Subject: Shoreline Exemption Permit, Pump Station 24 – 4606 E. Mercer Way.

This is a written response to the review comments provided by the Community Planning and Development Department regarding the application for the Shoreline Exemption Permit, SHL23-010, for Pump Station 24 located at 4606 E. Mercer Way.

PUMP STATION 24 -
PLAN

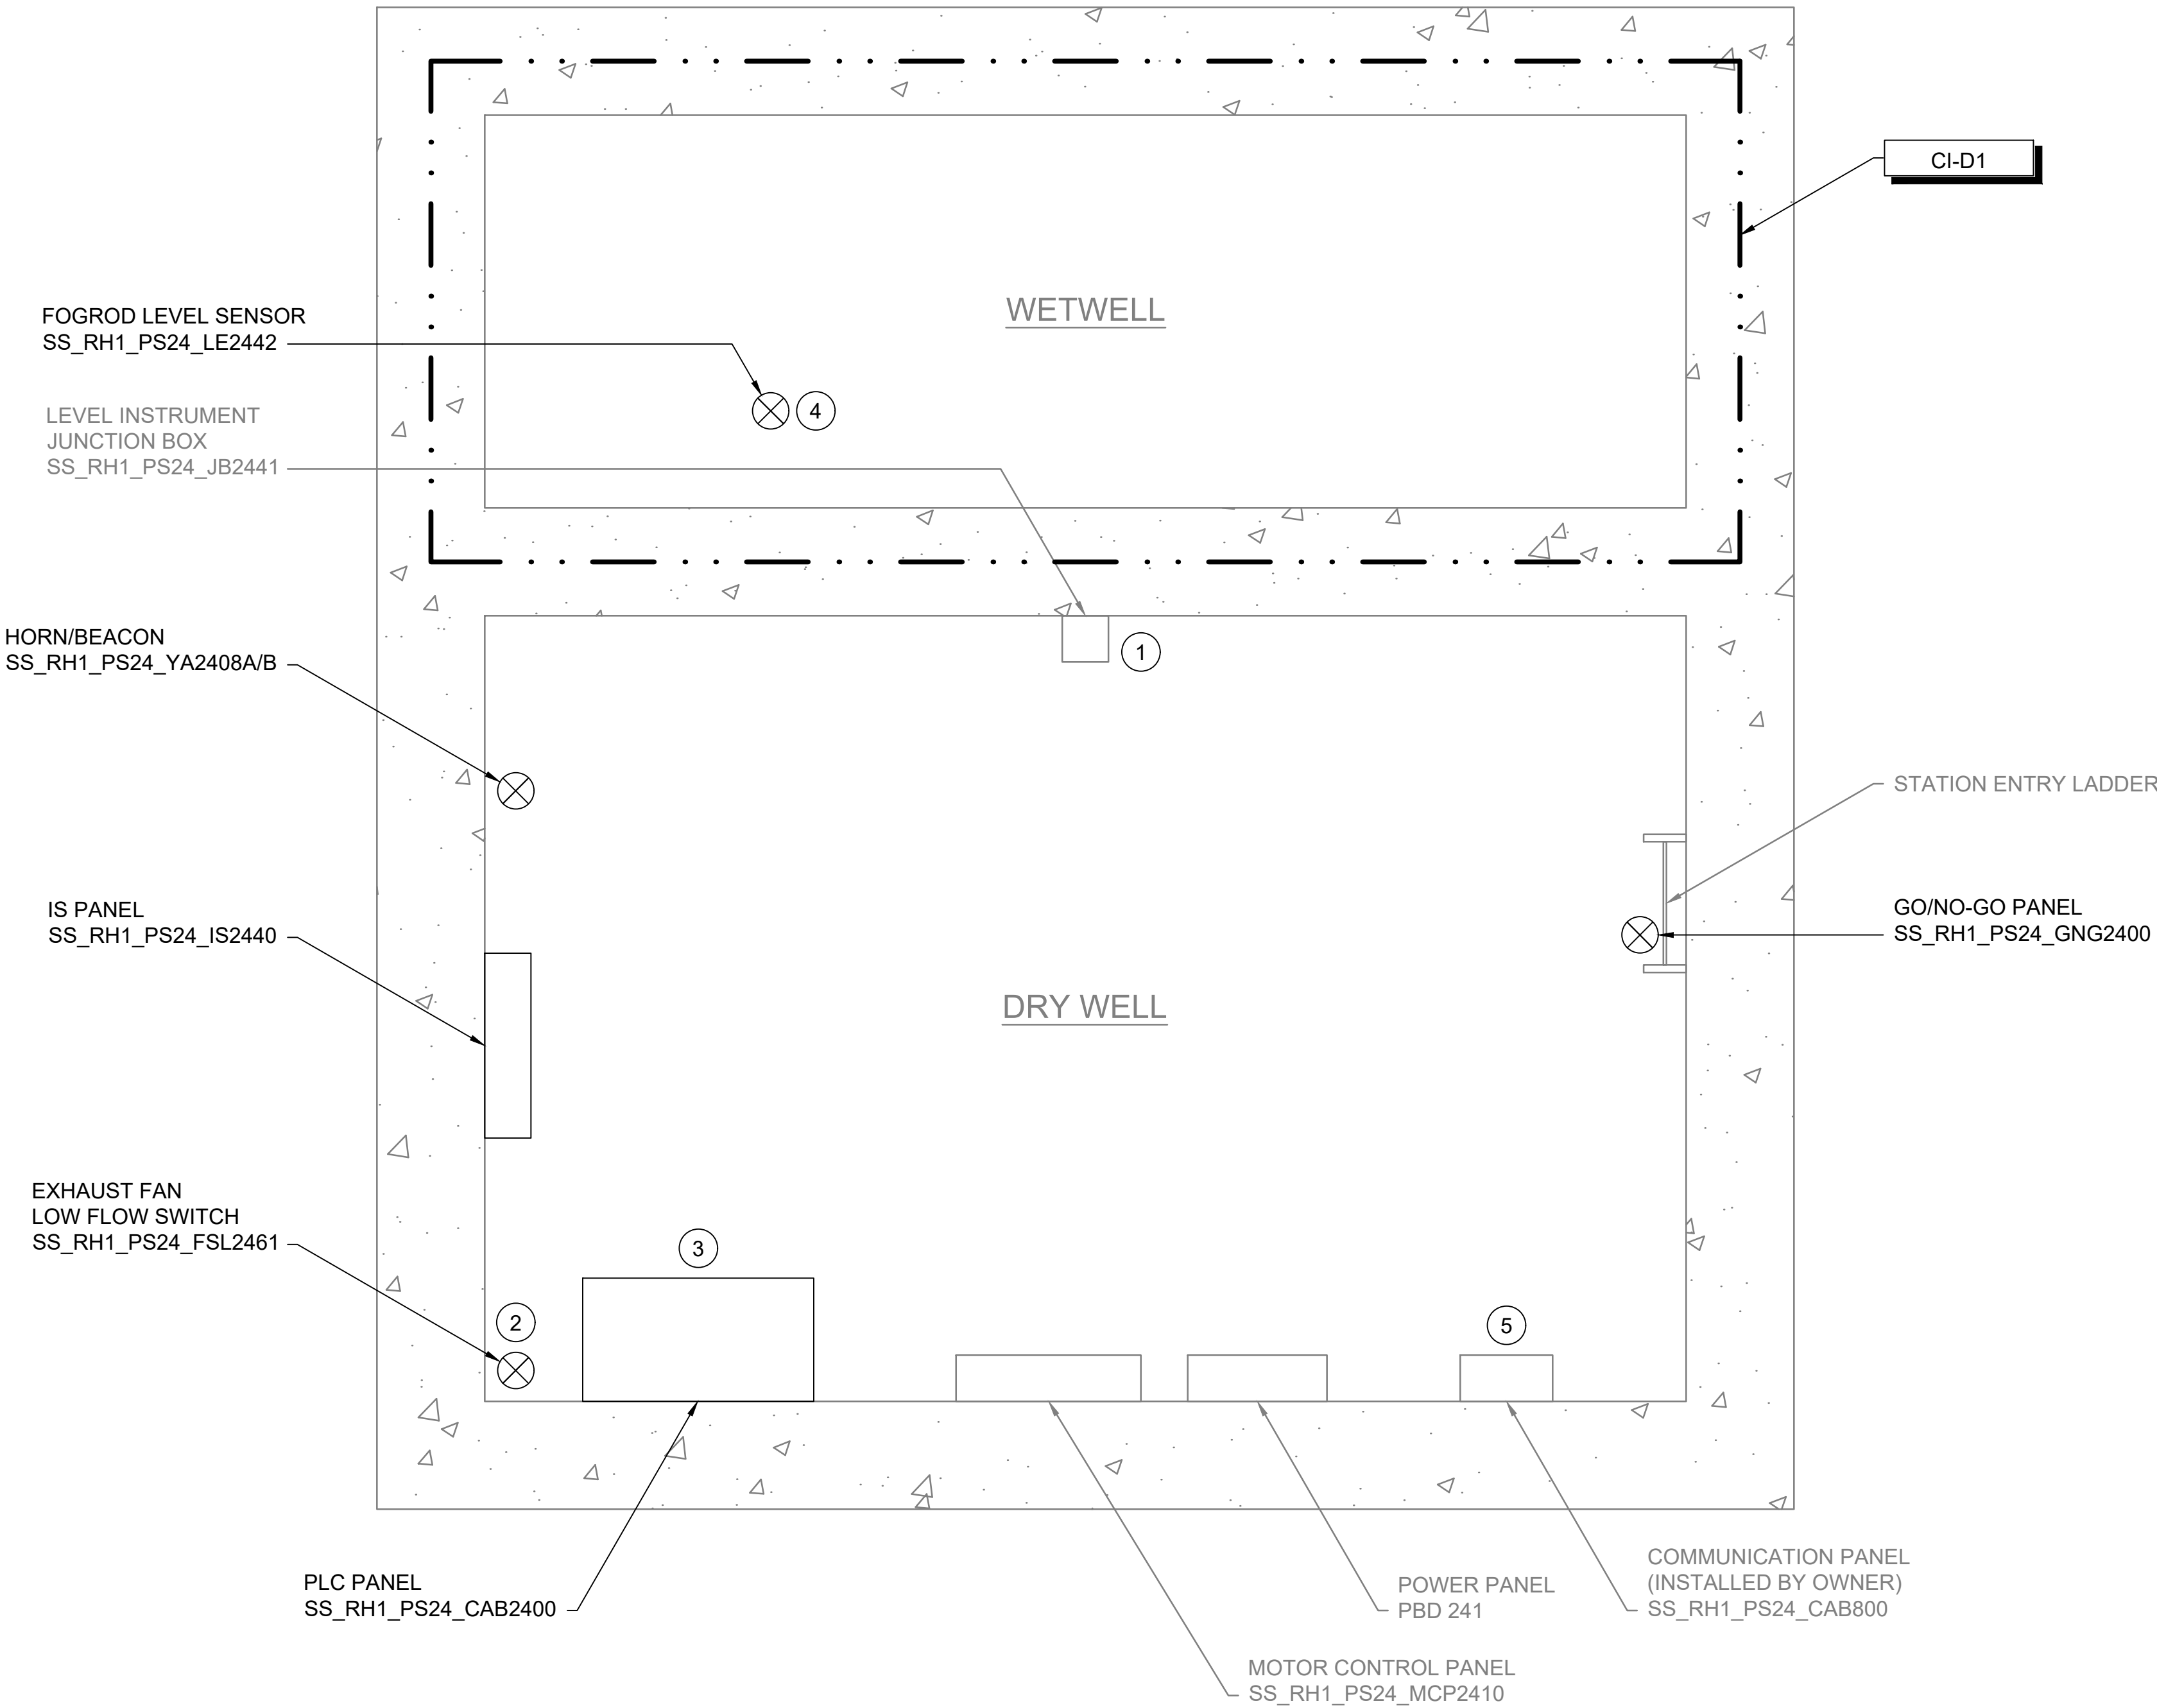
- a. Provide address of all pump stations on plans

Response: *The address for the pump station has been added to Development Plan, Instrumentation Drawing page 1. The address was also included in the aerial photo of the pump station.*
